Technical Note

Project No: ITB16357
Project Title: Land South of A259, Angmering
Title: Additional Information – A/169/21
Ref: DS/ITB16357-008
Date: 1 October 2021

1.1.1 Redrow Homes has appointed i-Transport LLP to provide highways and transport advice in relation to a planning application (planning ref: A/169/21) that has been submitted to Arun District Council (ADC) for the formation of a new access to land south of the A259.

TITLE:		ACCESS ARRANGMENT		DRAWN:	JD	CHECKED:	DS	APPROVED:	DS
PROJECT:		CLIENT:		PROJECT No:	ITB16357	SCALE @ A3:	1:1000	DATE:	08.07.21
LAND SOUTH OF A259, ANGMERING		REDROW		DRAWING No:				ITB16357-GA-008	
								REV:	
								A

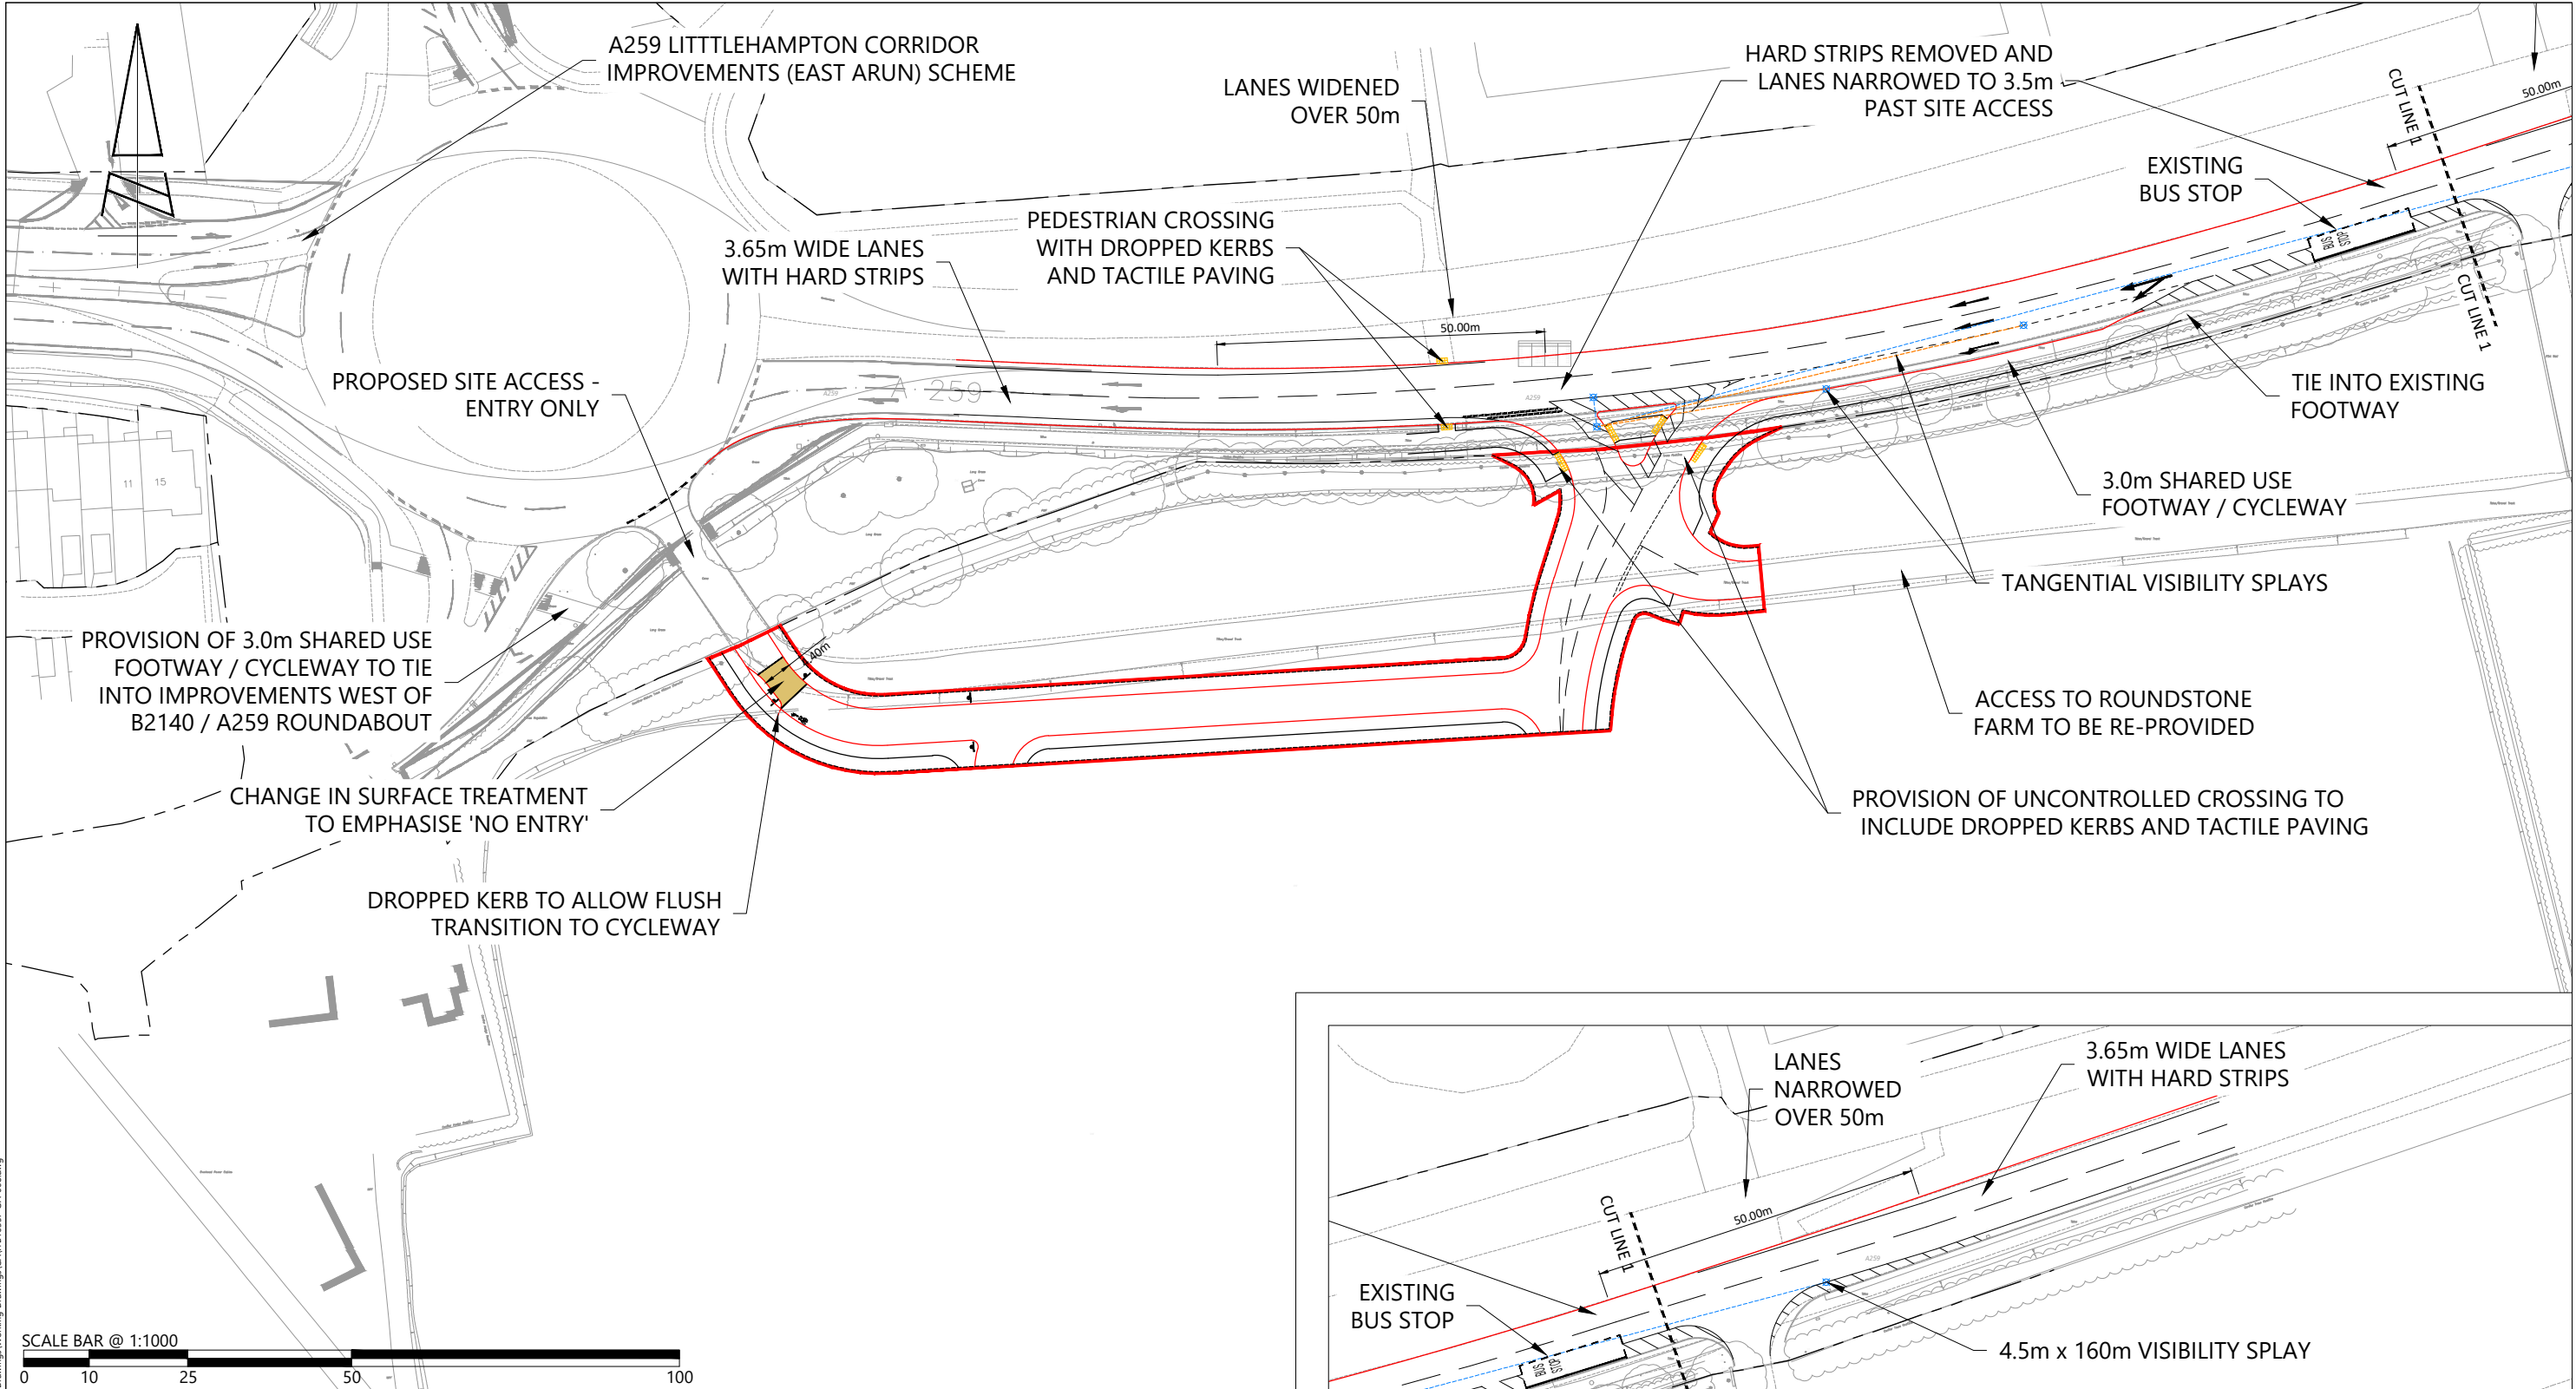
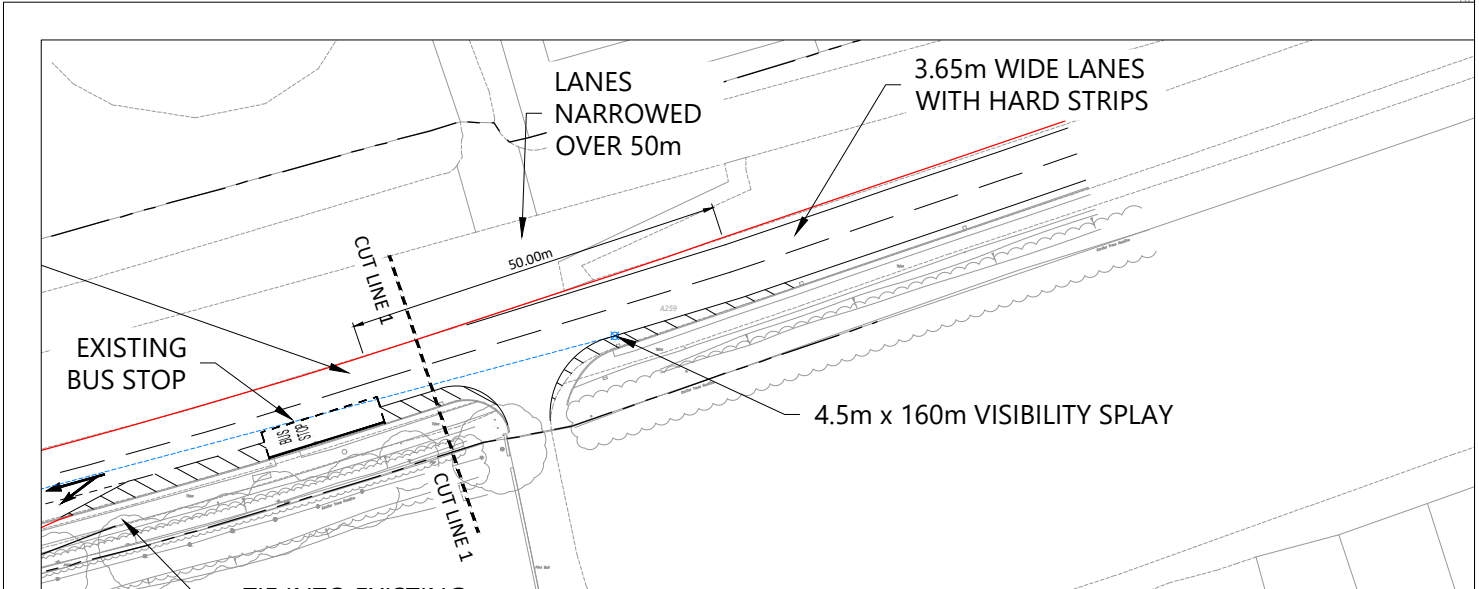
1.2.1 The design of the site access arrangement has been modified in order to remove the existing bus stop located on the live nearside lane of the A259 carriageway, as requested in the WSCC response. The amendment is shown in **Drawing ITB16357-GA-008 Rev A**.

A	01.10.21	MC	BUS STOP REMOVED	DS	DS
REV	DATE	BY	DESCRIPTION	CHK	APP
STATUS: FOR INFORMATION
